PROJECT NO. PR-2021-005459

Application No. SI-2021-01248

SUBMITTAL DESCRIPTION: Response to DRB Comments Letter, Revised Site Plan and details addressing Transportation

**RE: PR-2021-005459 RESPONSE TO DRB COMMENTS
LOT 1A BLOCK 2 & LOT 2-A-1 BLOCK 2 SUNPORT PARK
2900 TRANSPORT ST NE**

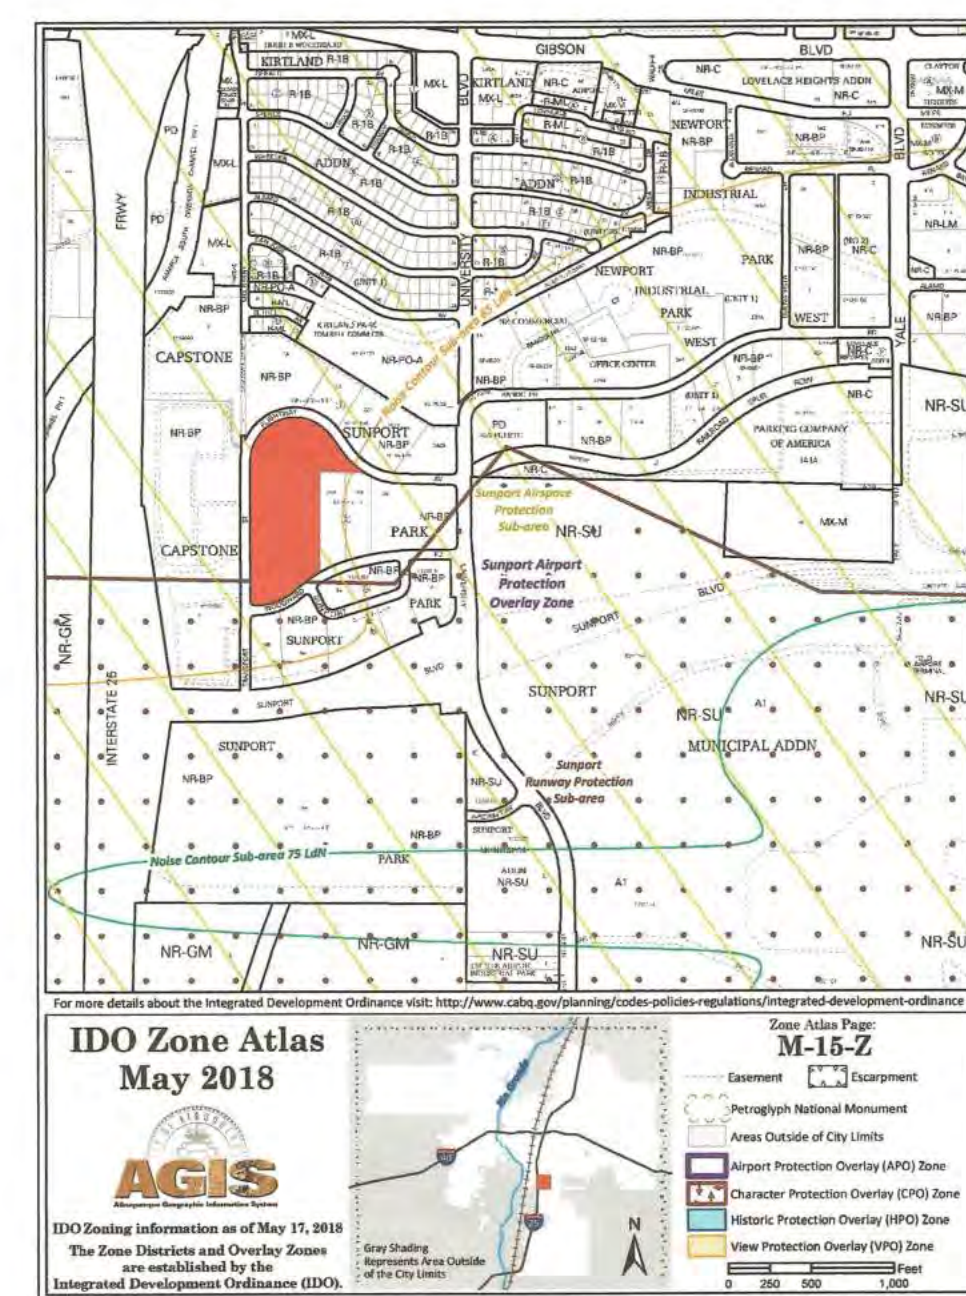
6. For the adjusted parking near the north accessway (parking beneath building), the accessway for handicapped spaces shown along the back appears to conflict with the infrastructure to the south and does not quite match recent discussions. On the overall site plan, make reference to detail sheet. (In order to make it fit, keep in mind that the minimum dimensions are 24-foot aisle, and 18-foot spaces.)

BUILDING 400 SOUTH ELEVATION

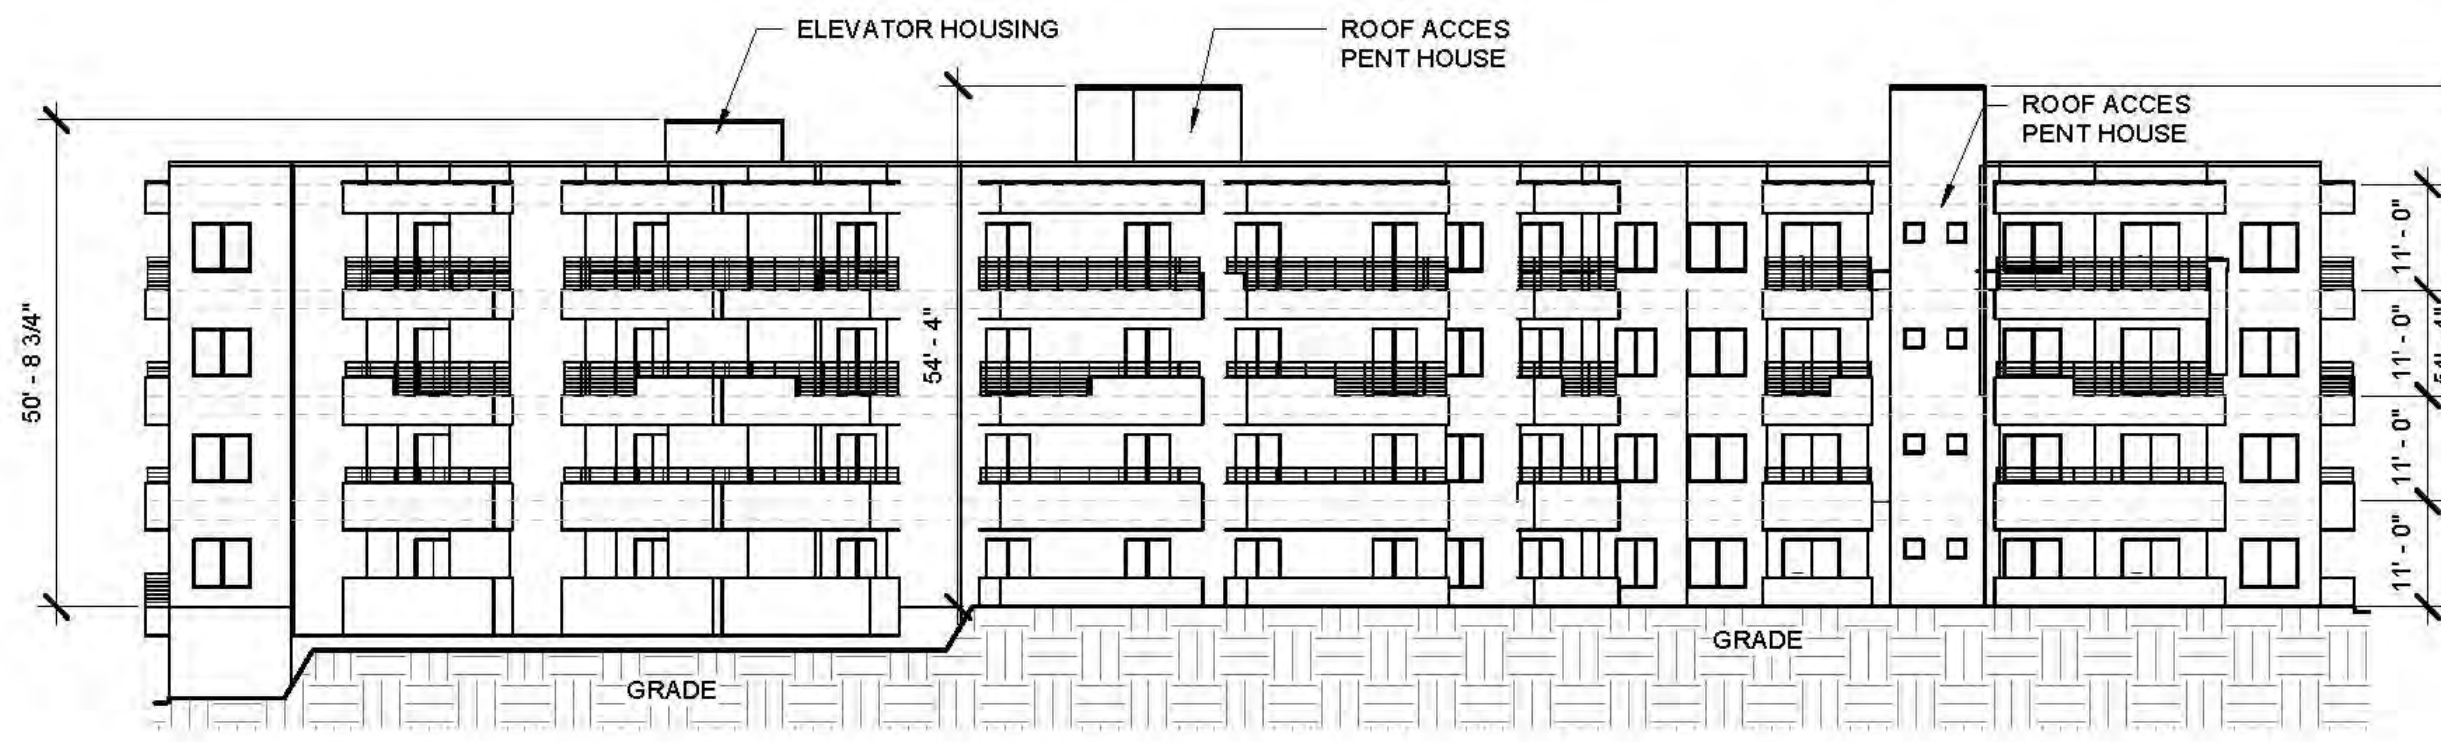
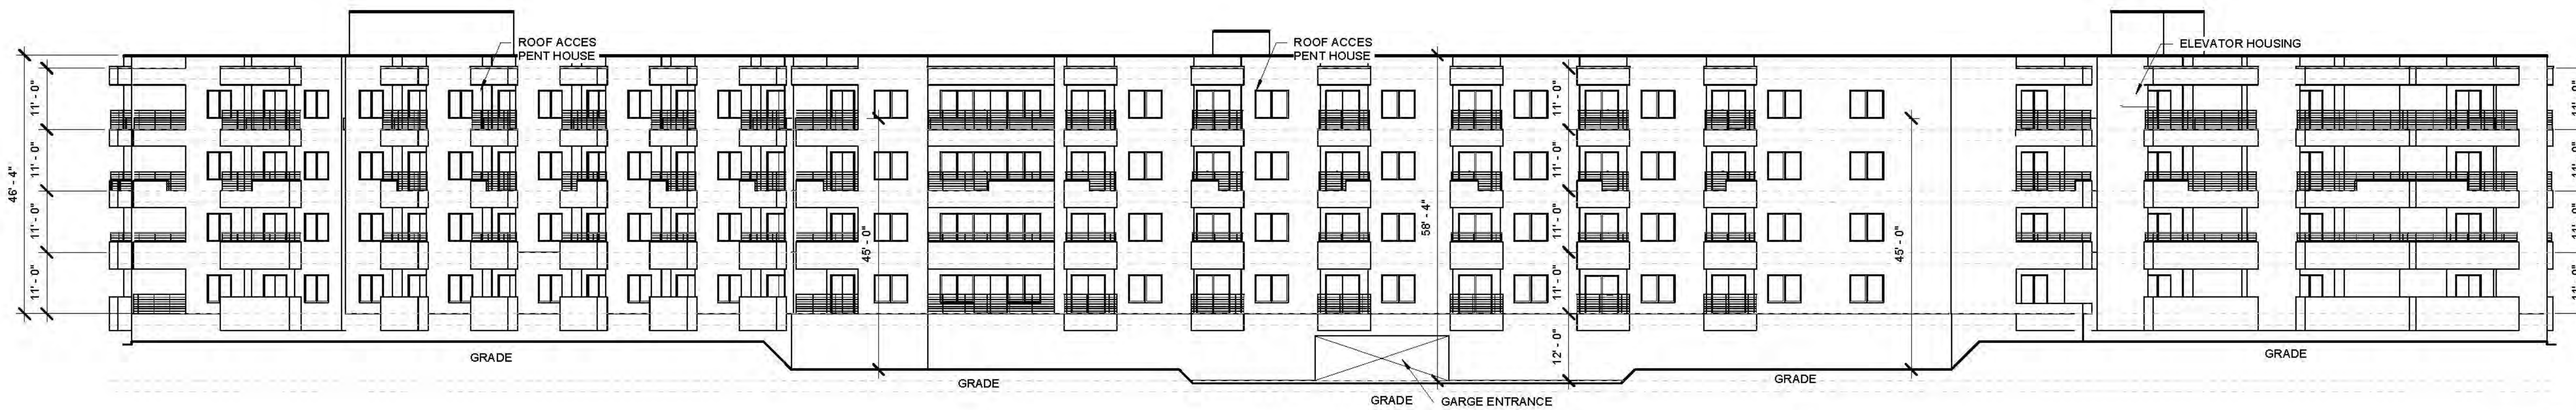
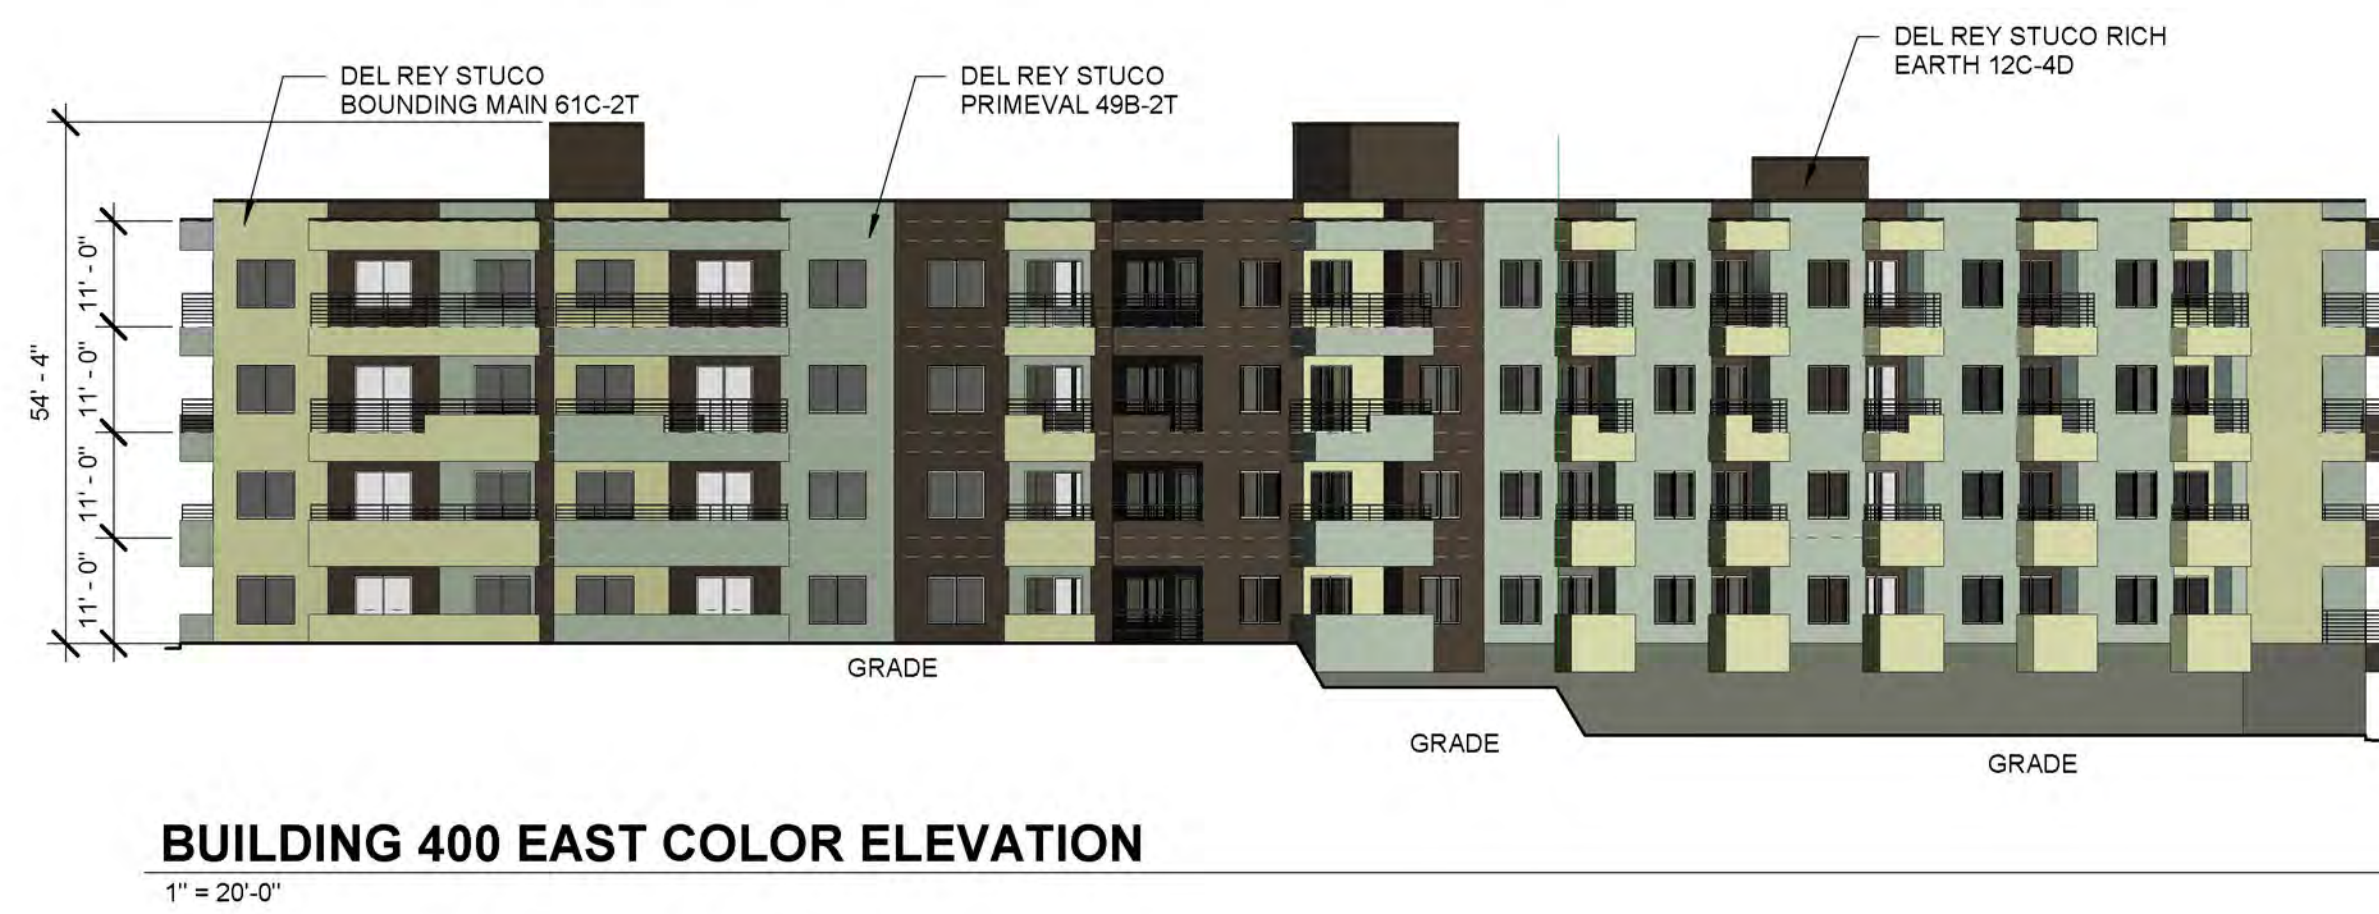
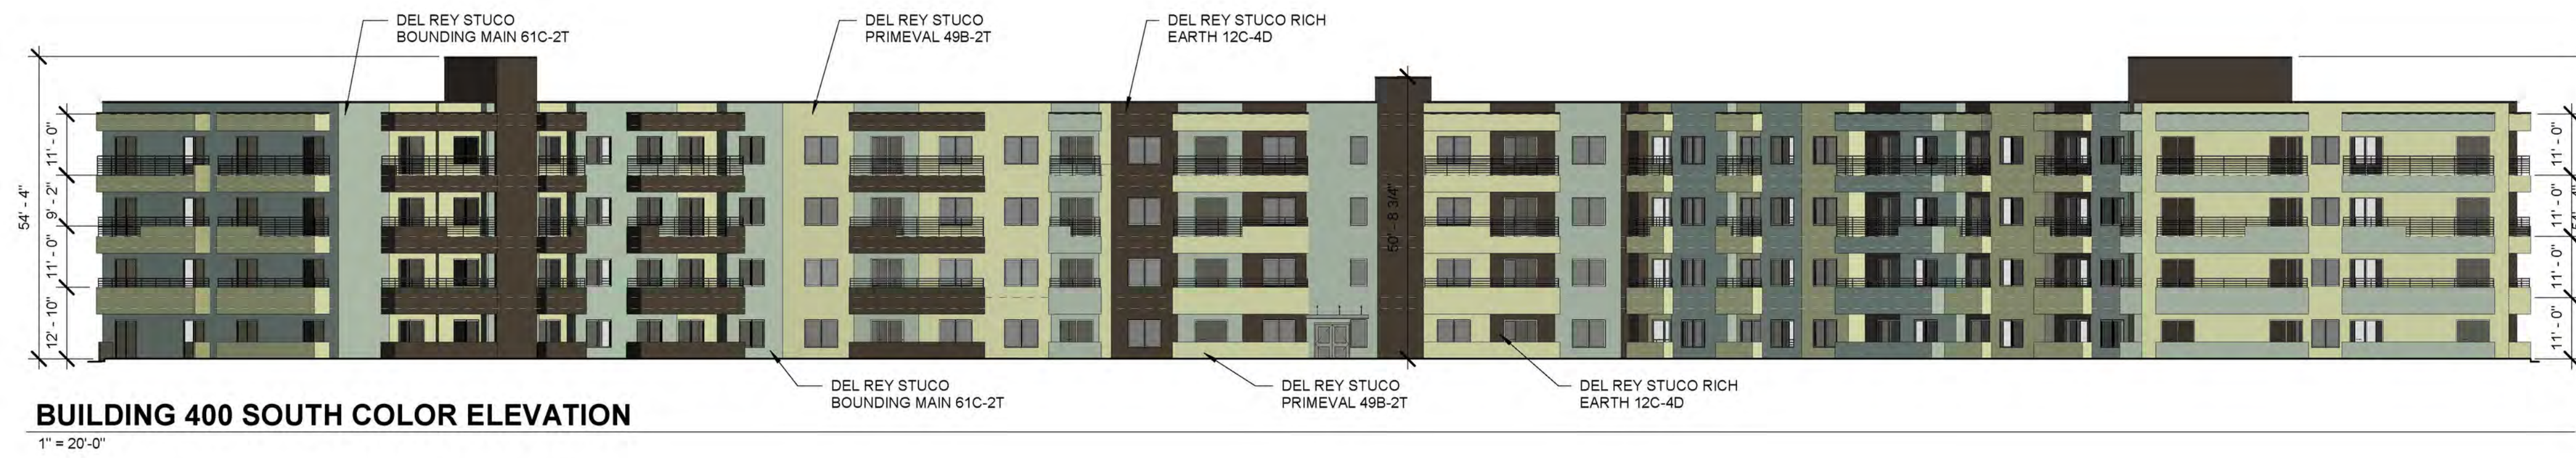
3. Please refer to the picture below regarding façade design suggestions.

RESPONSE: Reference the updated 3D images and the revised building elevations for building 400.

**SITE PLAN**

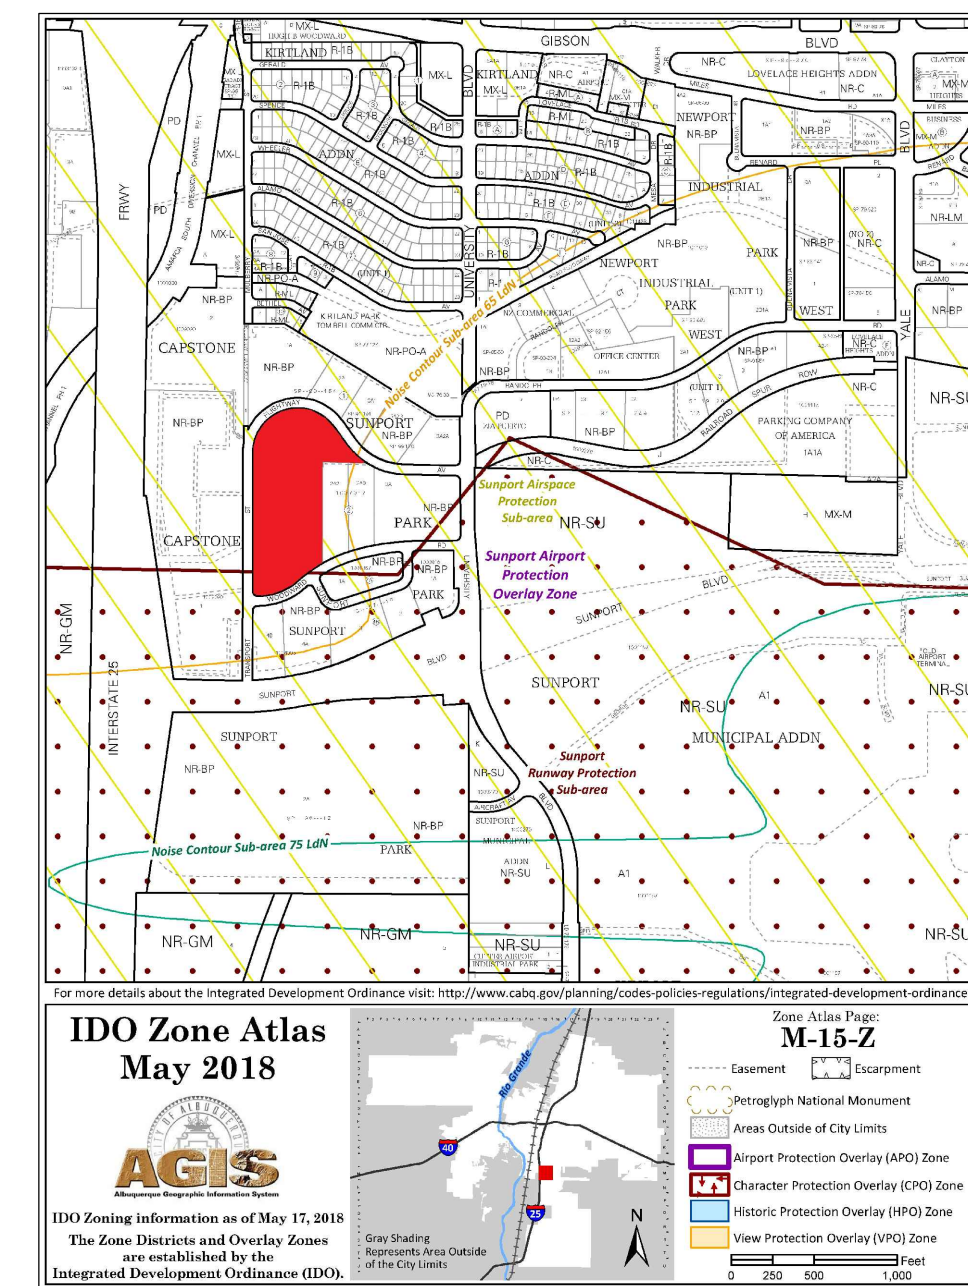
1. Roadway dimensioning for the east accessway is unclear. Because there are different dimensions for aisles, overall parking lot widths, and parking space lengths throughout the site, label typical dimensioning for each of the parking lot segments. (Two of the dimensions for the east accessway are shown in the thousands.)

3. To show 70 parking spaces outside of buildings, label number of bicycle parking spaces at each area labeled Keyed Note "B". (Dimension overall bicycle parking based on number of spaces.) Also, indicate electrical charging stations on the plan.

5. Make sure all ramps on-site are called out on the site plan. When referencing standard details 2442 and 2443, call out the correct detail reference from each of these COA drawings.

7. Please add a note on the plan stating "All improvements located in the Right of Way must be included on a public work order."

1. Lighting and light poles need to be noted and depicted on the Site Plan to ensure conformance with 5-8 of the IDO.

RESPONSE: Roadway dimensioning has been revised on Sheet A-001 with an architectural stamp date of 10/14/21.
2. For Keyed Note K on the turndown edges, these would typically apply to areas along the parking lot. Make a distinction with keyed note between areas that have turndown edges versus no turndown edges. Provide a detail for the sidewalk turndown edge, too.

RESPONSE: Bicycle parking spaces and quantities have been added to the site plan.
4. The ADA access aisle shall have the words "NO PARKING" in capital letters, each of which shall be at least one foot high and at least two inches wide, placed at the rear of the parking space so as to be close to where an adjacent vehicle's rear tire would be placed. (66-1-4.1.B NMSA 1978)

RESPONSE: Ramps have been called out. Wording to keyed notes V and W have been edited to include specific City Standard Details. Keyed note Y added to call out City Work Order ramps.

RESPONSE: Note added to A-001 "ALL IMPROVEMENTS LOCATED IN THE RIGHT OF WAY MUST BE INCLUDED ON A PUBLIC WORK ORDER"

RESPONSE: Reference note on site plan, all site lighting will be done with light bollards and wall mounted fixtures and shall comply with 5-8 of the IDO.
